WRITTEN REPRESENTATION

HIGHWAYS ENGLAND'S RESPONSE

ADDITIONAL COMMENTS FROM JASON NEWMAN ENVIRONMENTAL QUALITY TEAM MANAGER

Figure 7 – Construction Compound 9

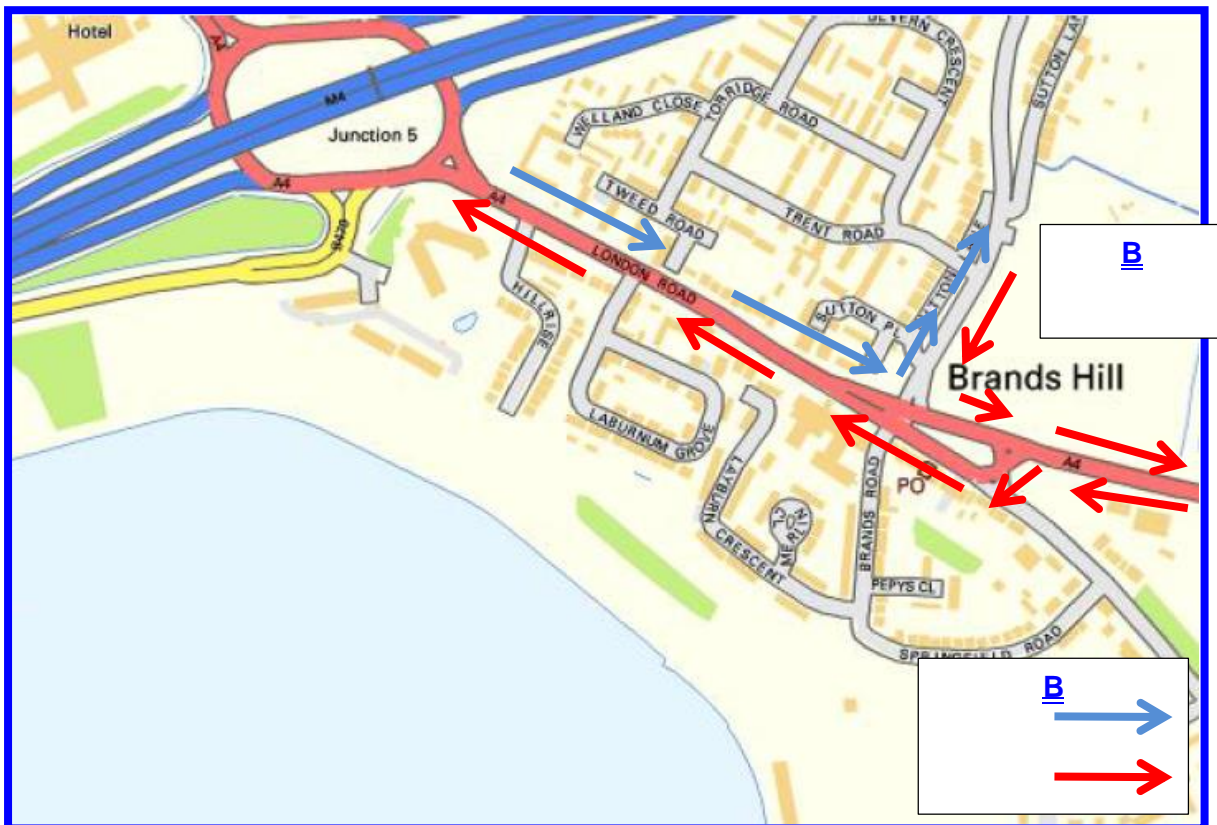
1.18 *SBC also raises concerns about residential receptors that may be affected by construction phase impact, in particular location of Compound 9 within our AQMA 2. This AQMA2 illustrated in Figure 1 below is experiences some of the highest concentrations of air pollution with the Borough.*

1.19 Details of our diffusion tube network within the Brands Hills AQMA 2 and AQMA M4 are illustrated in Figure 2 below. As compound 9 is located within the area between Sutton Land and London Road partly within the Brands Hill AQMA2 all construction traffic will need to operate through our AQMA2. The ES has failed to address construction phase impact as result of Construction vehicle movements and the HE has applied the DMRB screening approach (which requires a change in HGV trip flows of more than 200 AADT). SBC does not recognise DMRB criteria for requiring an air quality assessment on its strategic road network. SBC applied IAQM guidance “Land-Use Planning & Development Control: Planning for Air Quality” which requires a detailed air quality assessment be undertaken where there is a change of HDV flows of more than 25 AADT within or adjacent to an AQMA.

1.21 *SBC would recommend the construction compound is re-sited away from our local Air Quality Management Area, where this is not possible, that a detailed air quality assessment is undertaken to determine the impact on our residential receptors, and that HE also incorporates mitigation.*

1.18.1 Construction Compound 9 has already been identified as a site which will require the highest level of mitigation measures for air quality due to its proximity to residential properties. These measures are listed in the Outline Construction Environmental Management Plan (“CEMP”) (Appendix 4.2A of the ES) (Application Document Reference 6-3, APP-293).

1.18.2 Preliminary estimates of the construction traffic, presented in the Engineering and Design Report (“EDR”) (Application Document Reference 7-3, APP-096), indicate that on average it is expected that there will be an additional 150 heavy good vehicles (“HGVs”) on the local highway network daily, across the length of the Scheme route and between any construction compounds used. Therefore, it is

considered that a detailed air quality assessment will not be required for Construction Compound 9 as this traffic will be spread across the Scheme route and compounds.

- 1.18.3 However, if following the completion of any further construction compound construction traffic flow assessments, higher numbers of HGVs are anticipated (more than 200 HGVs per day over an annual duration), then an air quality assessment will be undertaken for Construction Compound 9 to determine the impact on local receptors and to determine whether any further mitigation measures will be required.
- 1.18.4 The Outline CEMP will be updated at Deadline V to reflect this commitment.

1.21.1 Highways England has addressed the points raised in response to paragraph 1.18 above.
